CGS Unique No. EP-26-0092_1 Flying Horse North Filing No. 9

El Paso File No. PUDSP263

The available referral documents include the PUD & Preliminary Plan Major Amendment (HR Green, June 25, 2026), Letter of Intent (HR Green Development, LLC, June 9, 2026), the Soils and Geology Study (Entech Engineering, Inc., April 15, 2026), and other relevant documents.

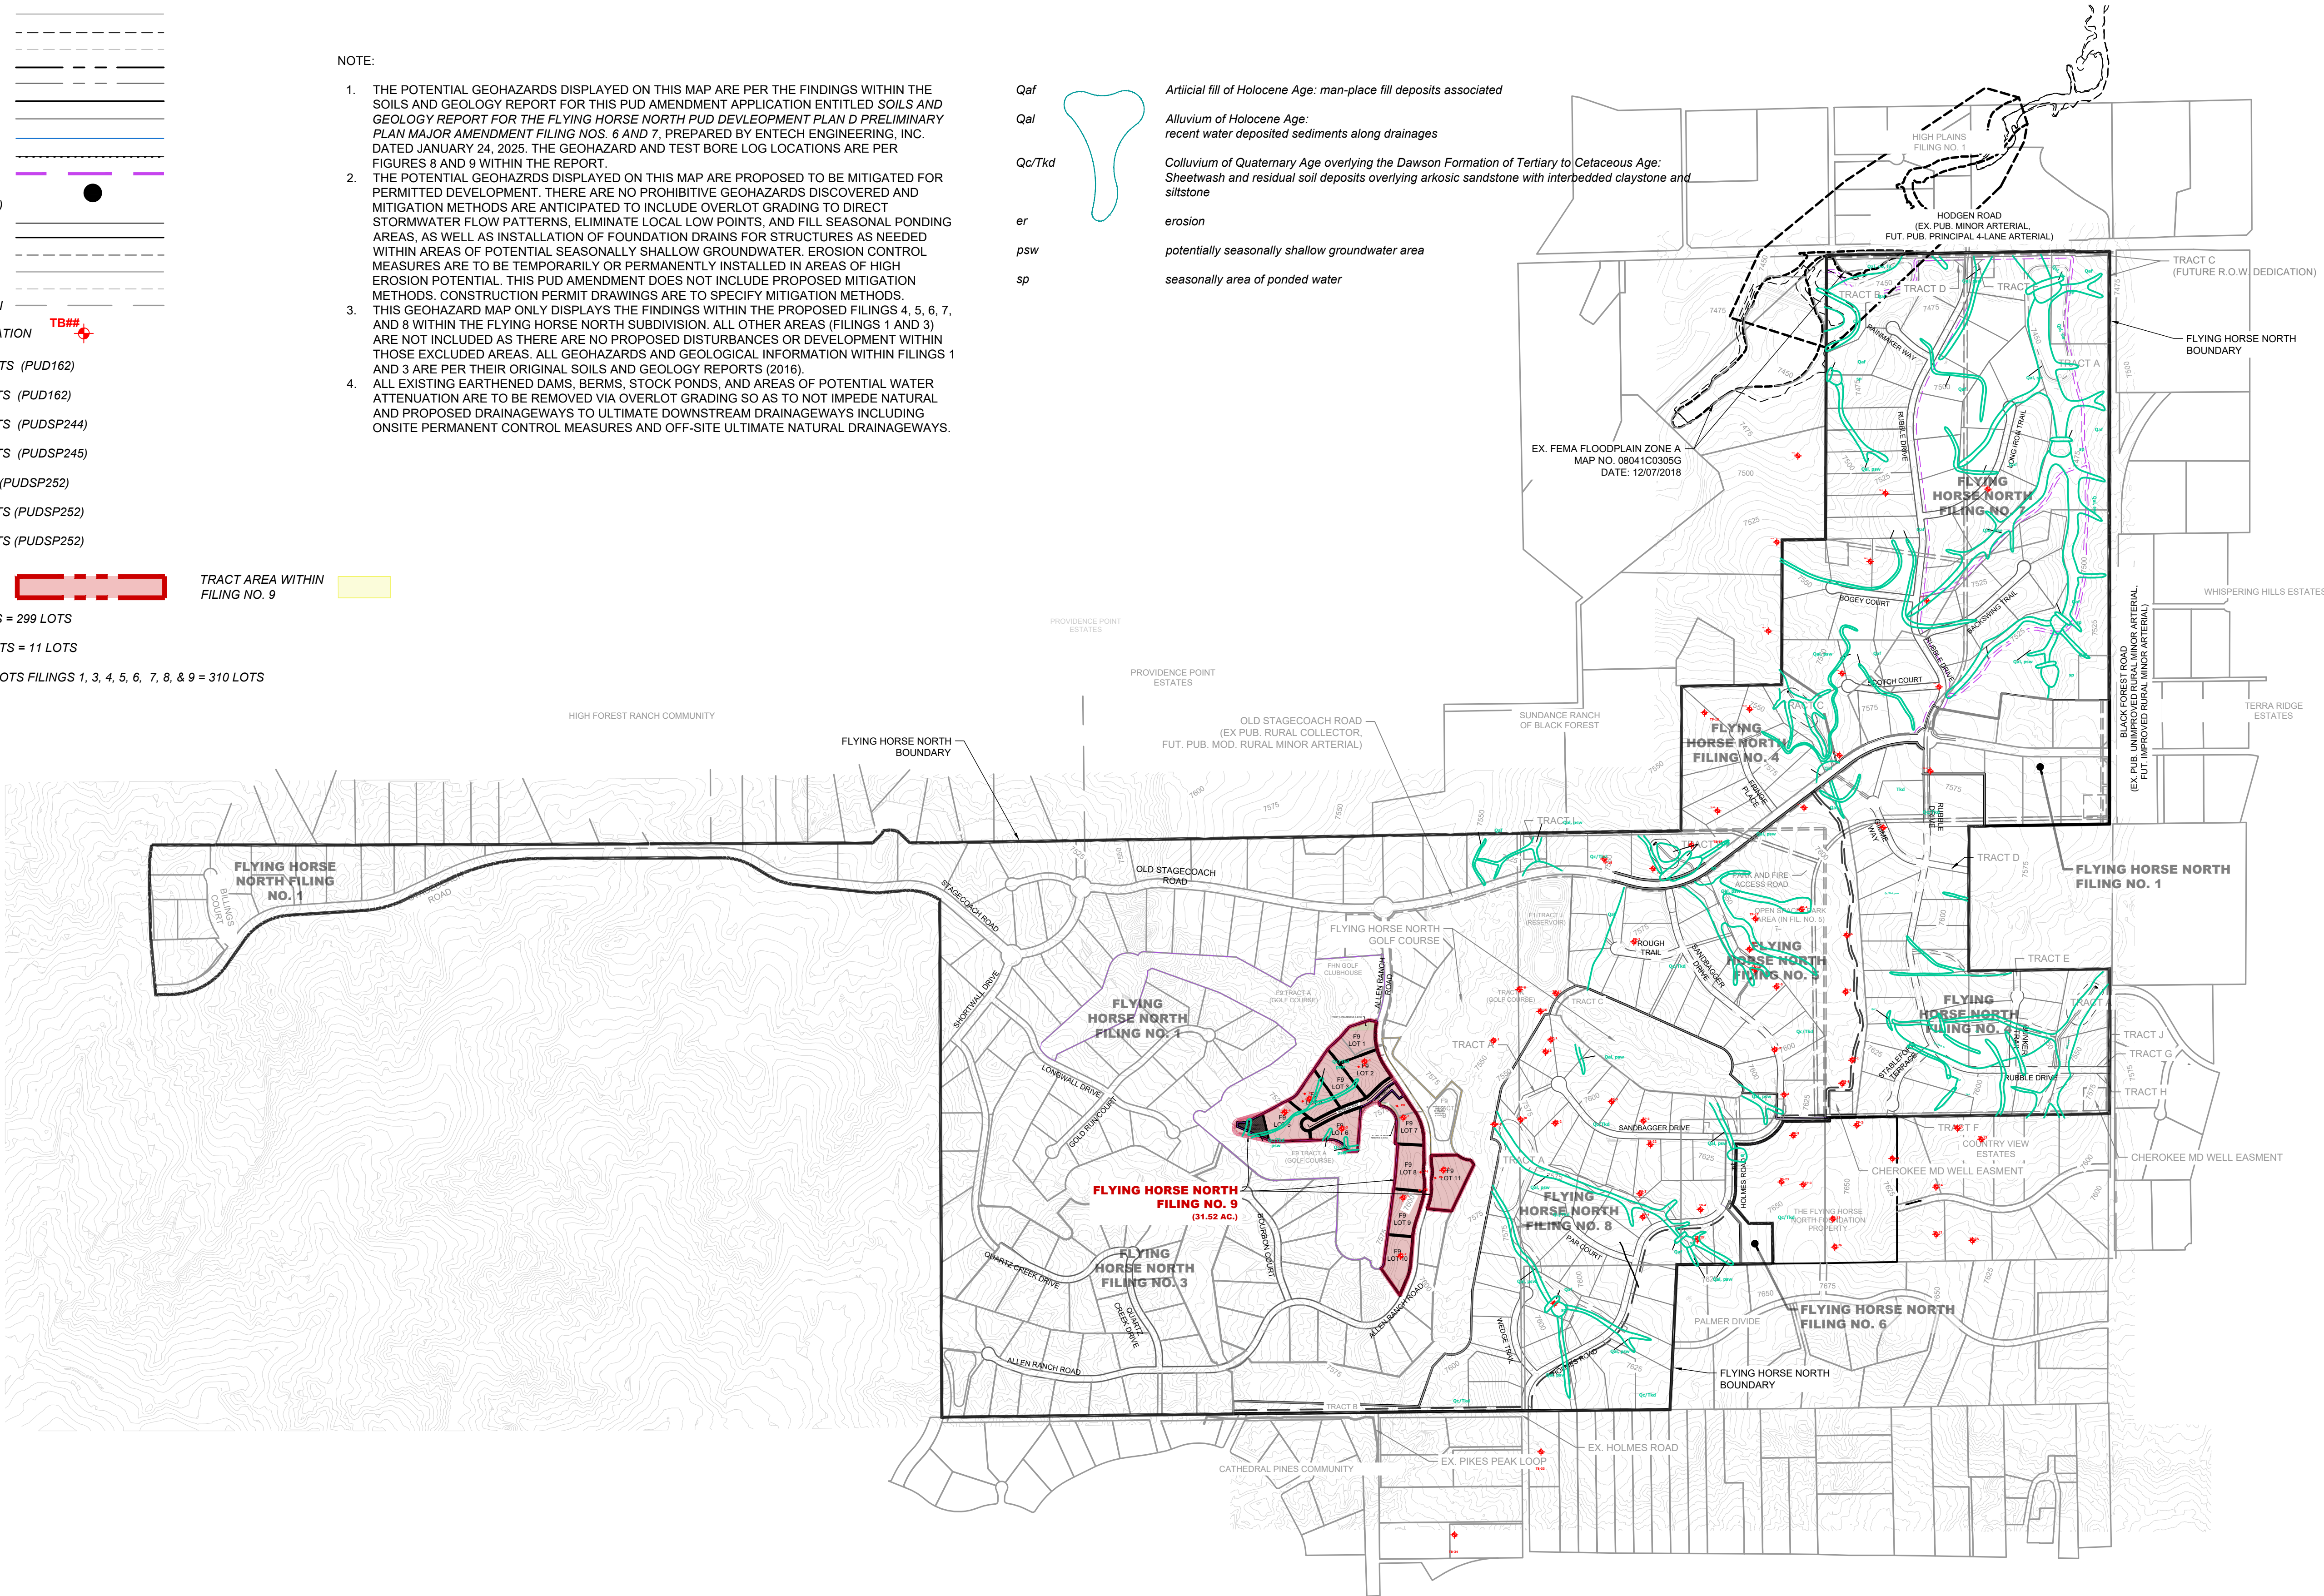
3. Multiple drainages exist within the project area. According to Entech’s study (Fig. 6), these drainages are identified as potential seasonally shallow groundwater areas (psw). The lots affected by these drainages include Lots 2-6 and Pond A. CGS recommends that erosional setbacks be established near drainages and noted in the plans. Building footprints should be outside the setback areas.
